City of Portland, Maine - Building or Use Permit Application

Permit No: 10-1218	Issue Date:	CBL: 057 D034001
-----------------------	-------------	---------------------

Location of Construction: 85 Gray St	Owner Name: Patrick DeLong Deloy	Owner Address: 85 Gray Street	Phone: 207-749-4098
Business Name:	Contractor Name: Don White & Son Inc	Contractor Address: 37 Valley Lane Sebago	Phone: 2073108534
Lessee/Buyer's Name:	Phone:	Permit Type: Alterations - Dwellings	Zone: R-6

Re: 85 Gray Street – 057 D034 – R-6 – rebuild deck & stairs – permit #10-1218

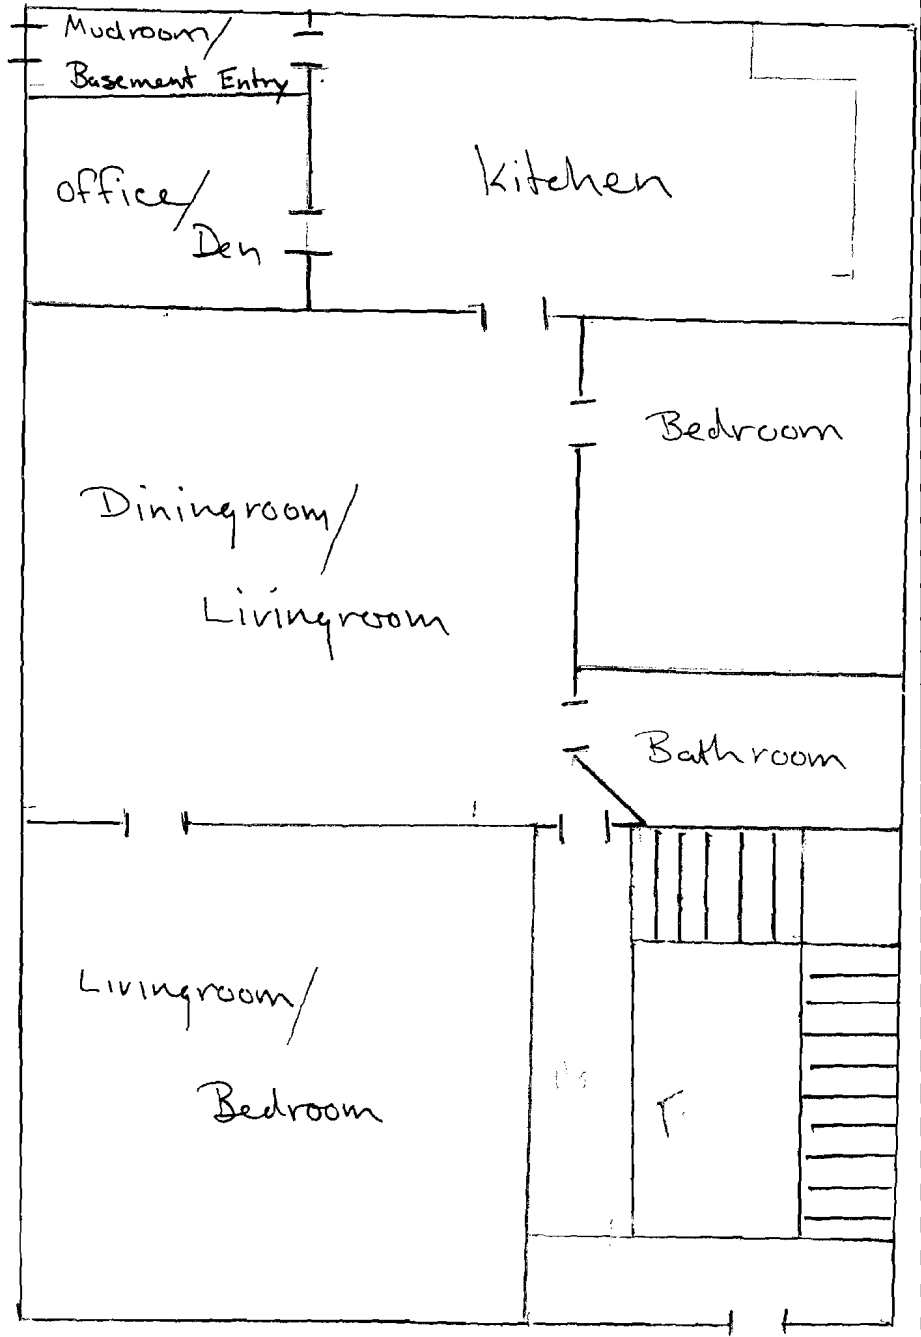
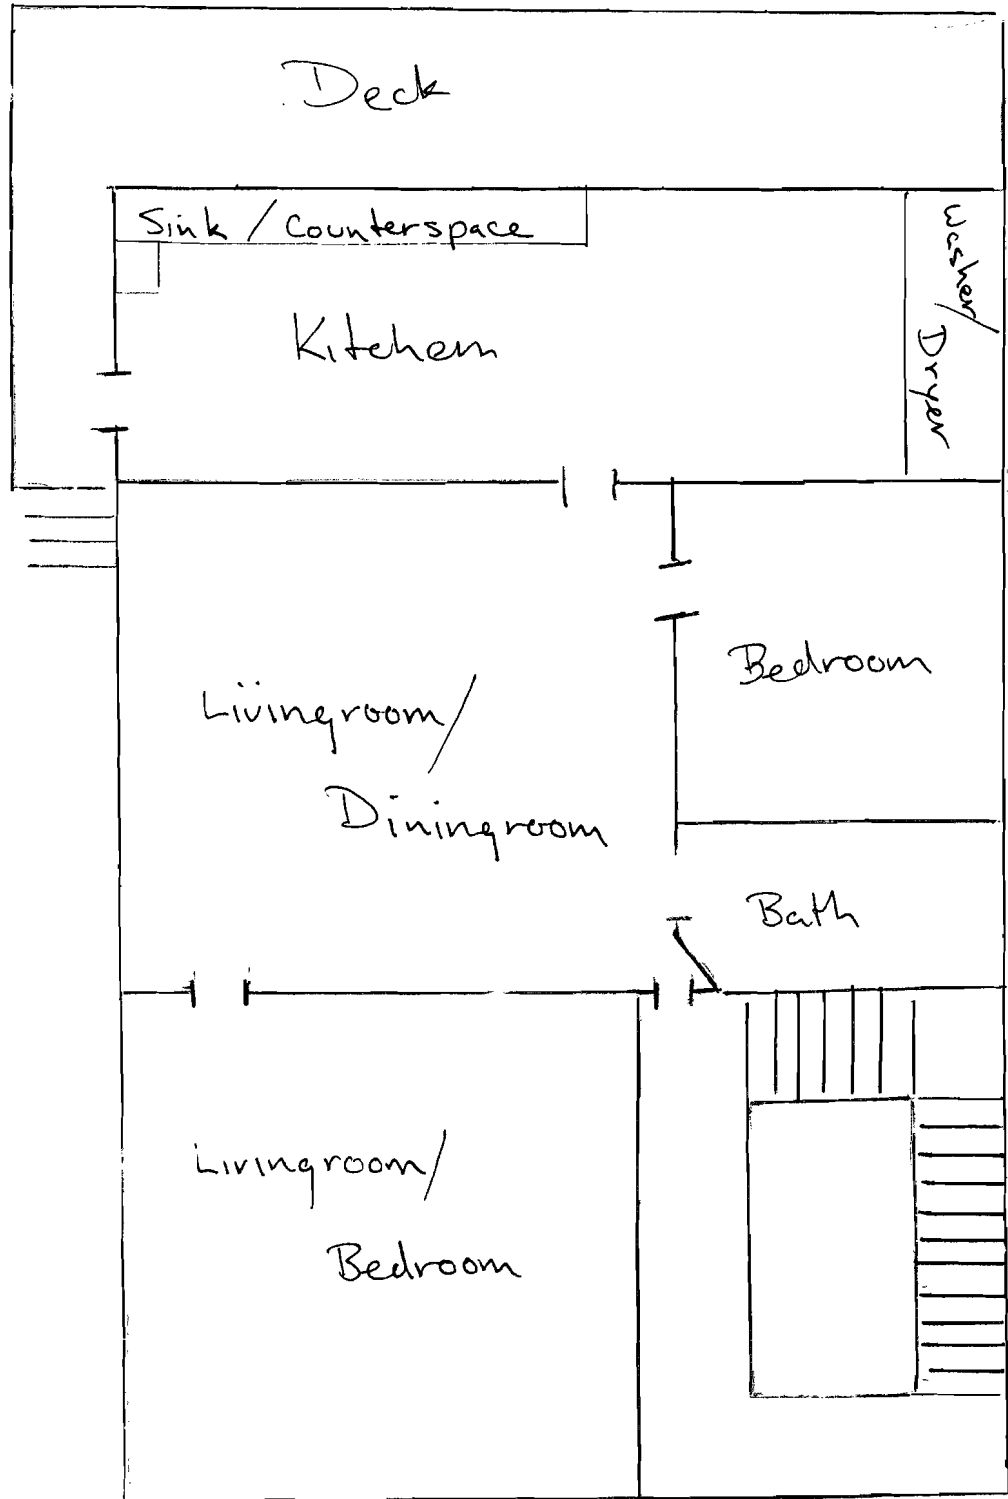
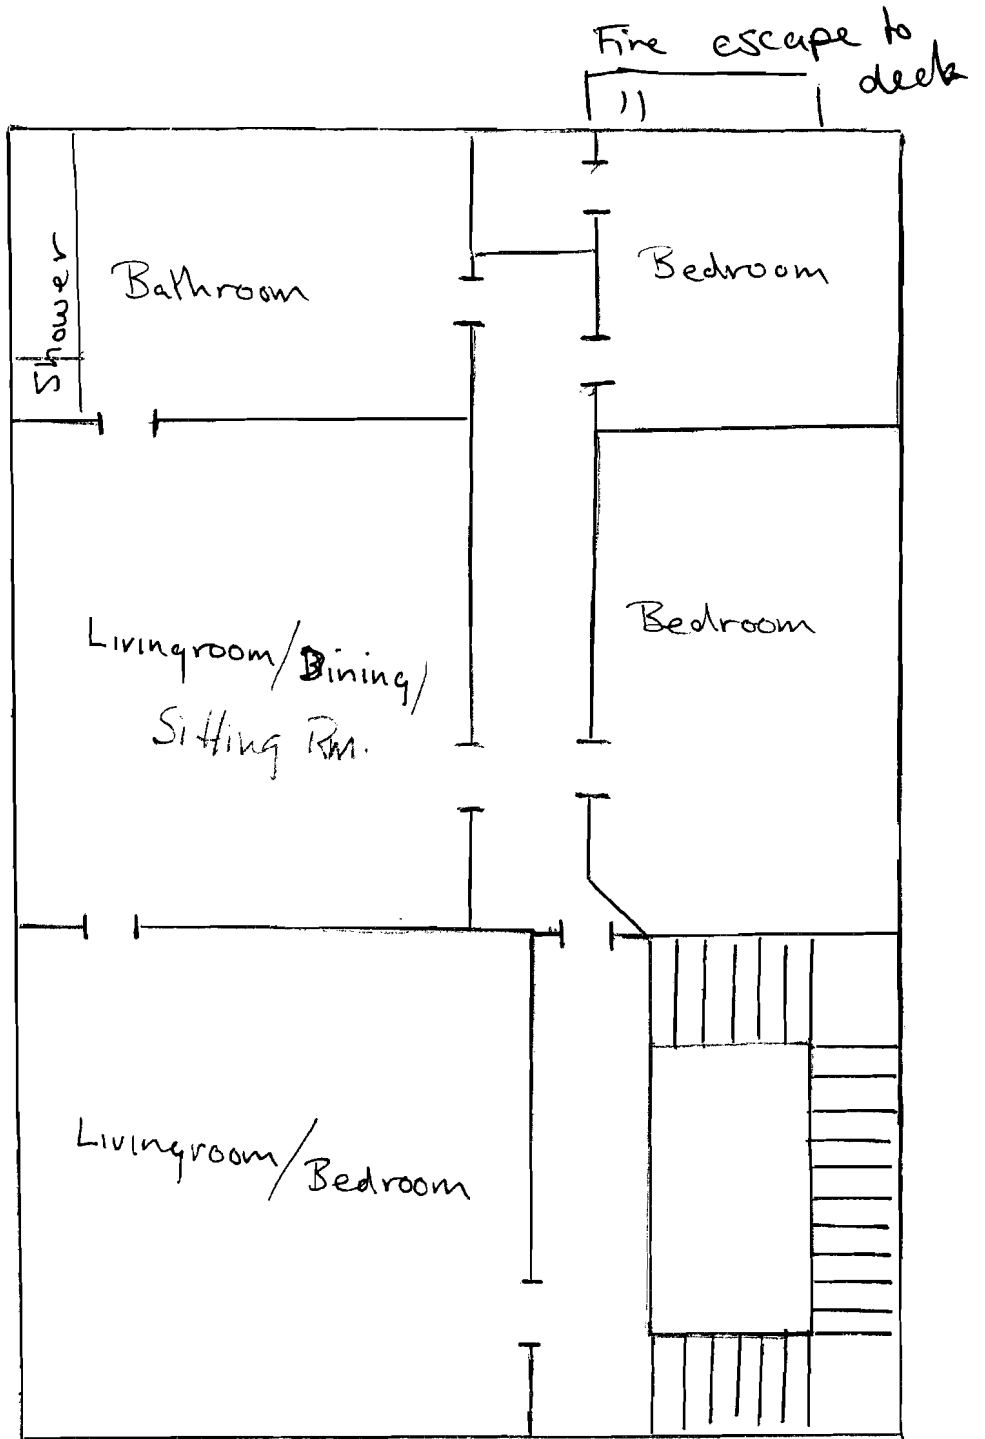
The deck and stairs at 85 Gray Street are nonconforming because they do not meet the required setbacks and lot coverage. 85 Gray Street is located in the R-6 residential zone. The required rear setback is twenty feet [section 14-139(d)(2)]. The plot plan gives the rear yard setback to the deck as four feet. The required side yard setback is ten feet [section 14-139(d)(3)(a)]. The plot plan gives the distances to the abutting buildings as eleven feet on the left and six feet on the right. The proposed stairs and deck need to be ten feet from the property lines. Finally, the maximum allowable lot coverage for the R-6 zone is fifty percent [section 14-139(e)]. The lot is 1969 square feet. The existing building, bay windows, and front entry cover 1060 square feet. The proposed deck and stairs cover 250 square feet of the lot. The total square footage would be 1310 square feet which would cover 66.5% of the lot.

Part of our review process when we receive an application to replace a structure that is nonconforming is to see if the structure was originally permitted. I have researched our files and I cannot find a permit to build an eight foot by twenty-three foot deck and a three foot by fourteen foot set of stairs. If the deck and stairs were not permitted, the deck is not legal, and it cannot be rebuilt. The property must be brought into compliance. You have thirty days from the date of the letter to do this. Our office will work with you to achieve compliance, but since there is no permit for the original deck, it needs to be removed.
